## Rezoning Petition Review – Charlotte Tree Ordinance

**Subject:** Urban Forestry Rezoning Petition Review Summary

**Rezoning Petition:** 2021-114

Date	Description/Status
9/23/2021	UF 2 <sup>nd</sup> review, Tim Porter

DATE: 04/19/2021 MPIC: WILL
DRAWN BY: DSB CHECKED BY: RAC
PROJECT NUMBER: 00867 00
SCALE: 1" = 30'
TITLE: TECHNICAL DATA PLAN
SHEET NO: RZ-1

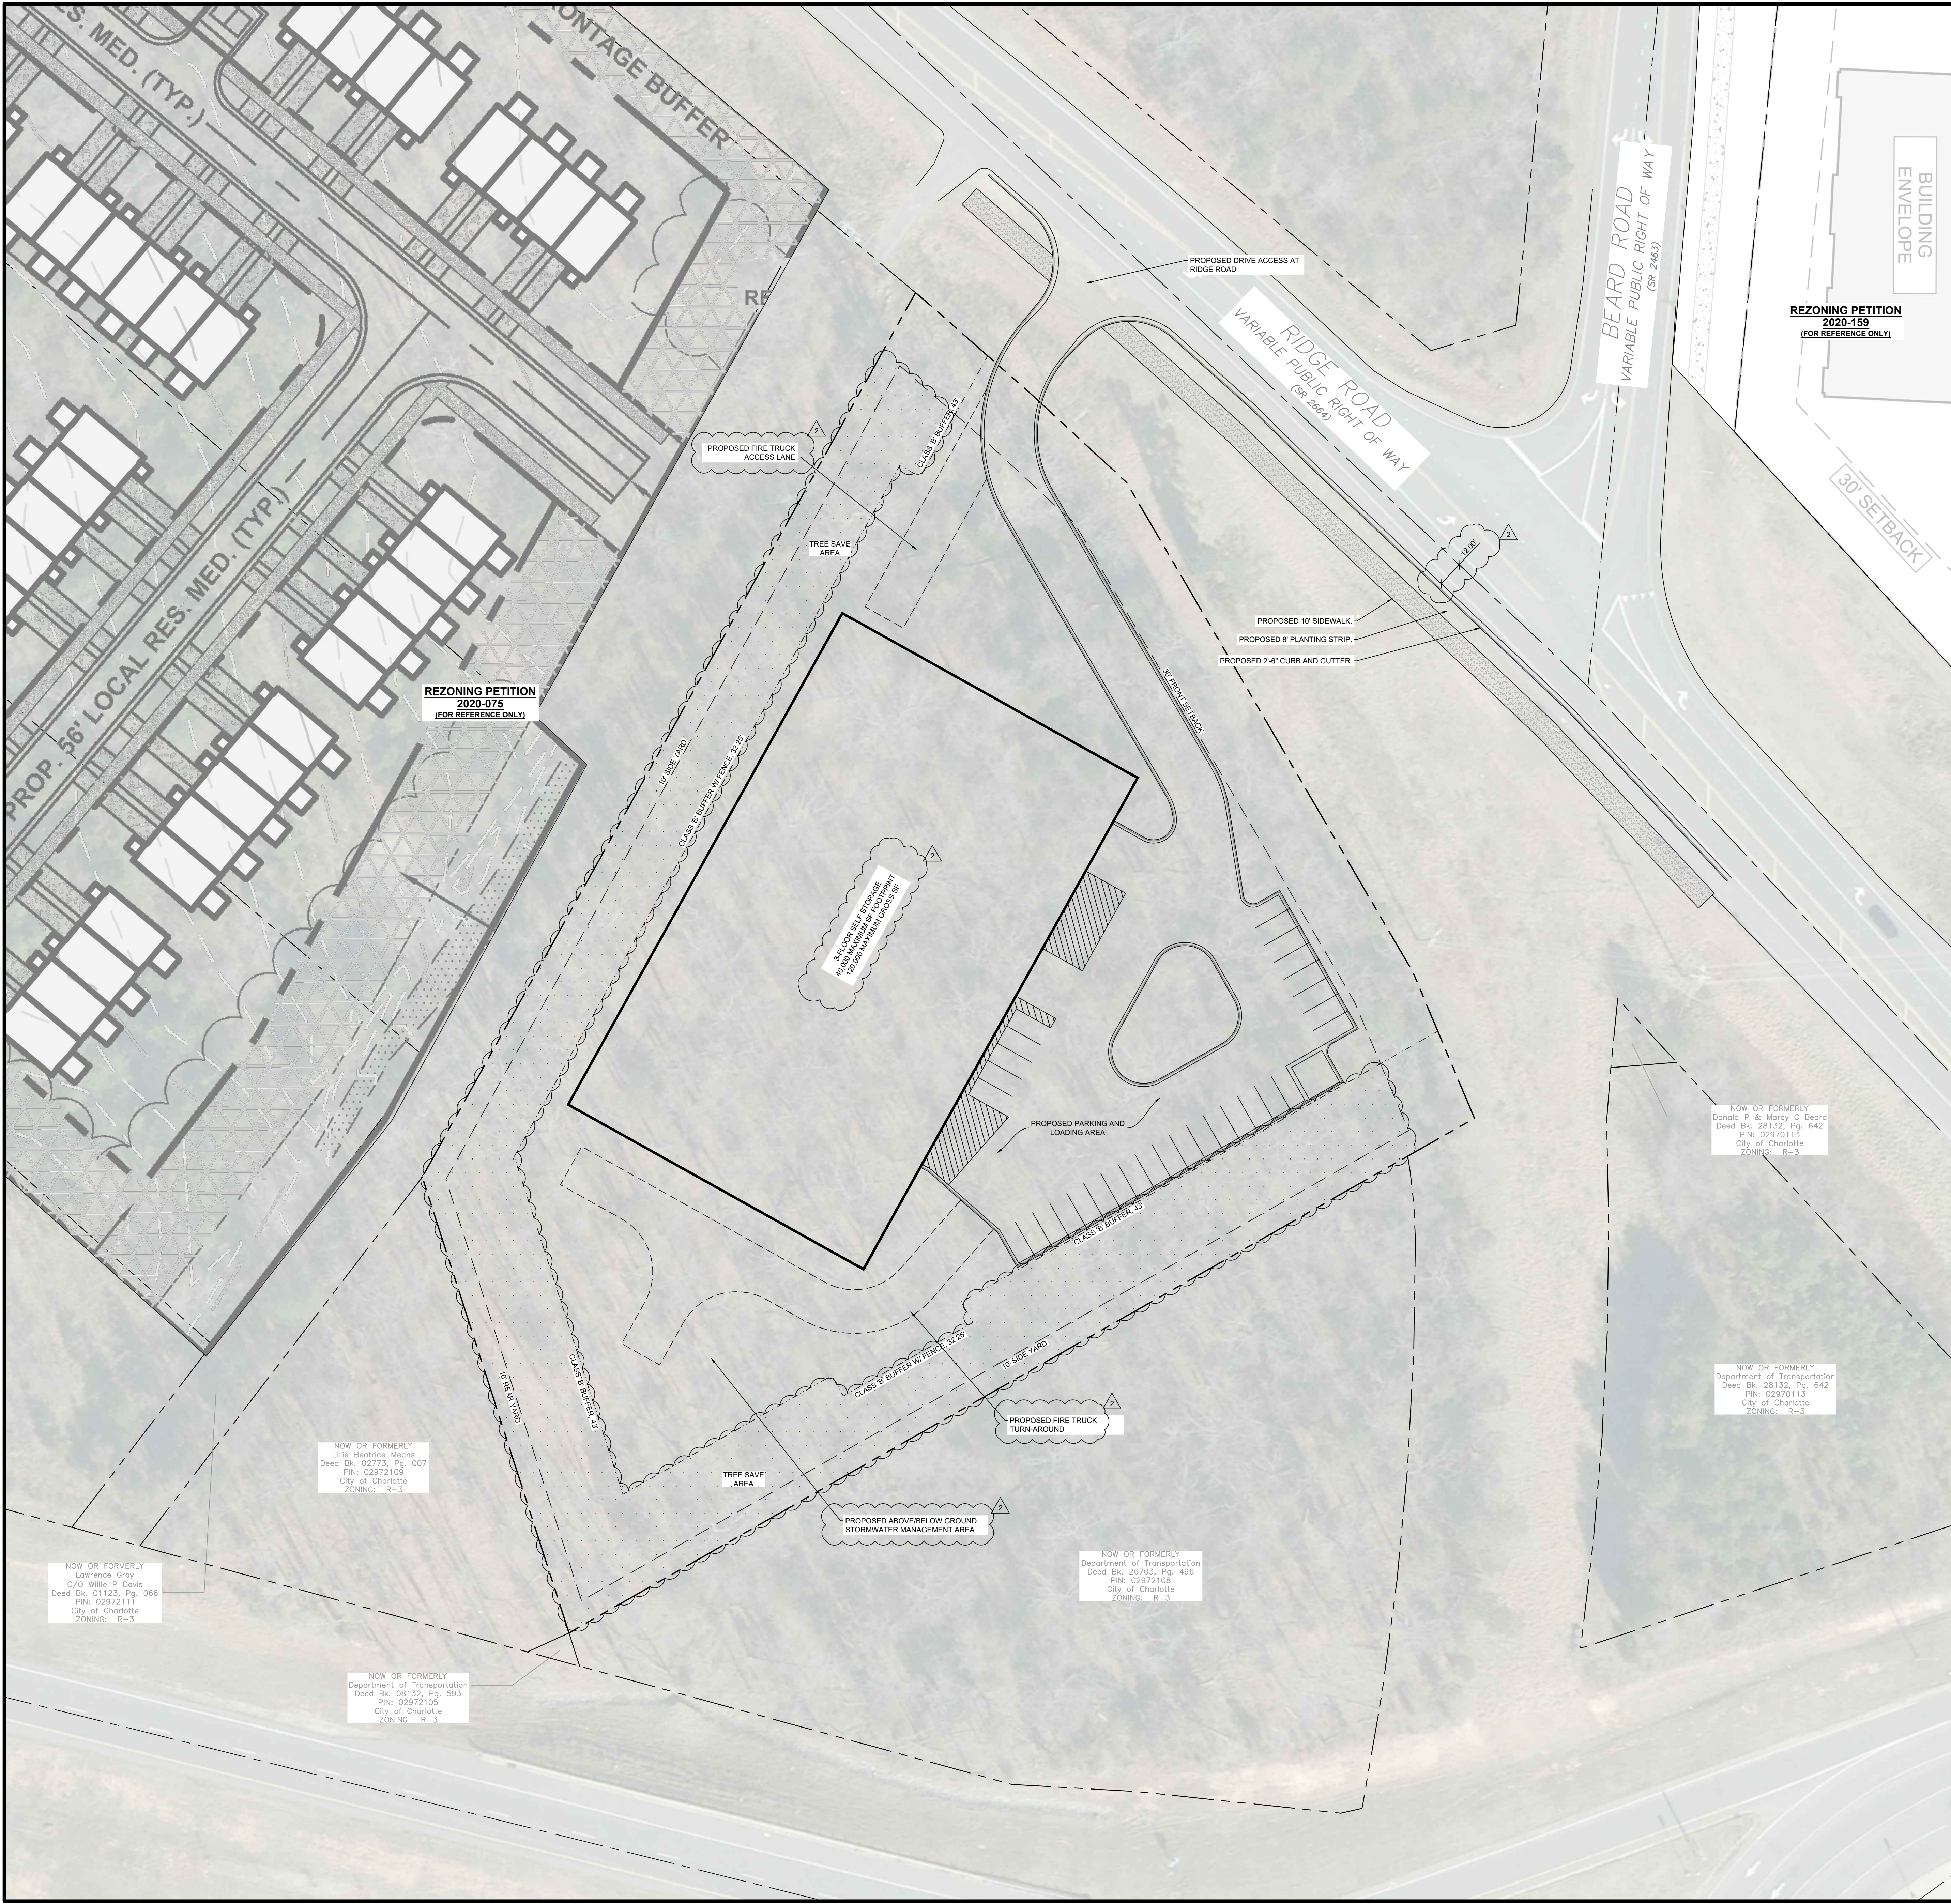
- ~~Tree survey not required for this petition.~~
- Remove specific tree save calculations. Final tree save requirements to be determined at time of land development permitting
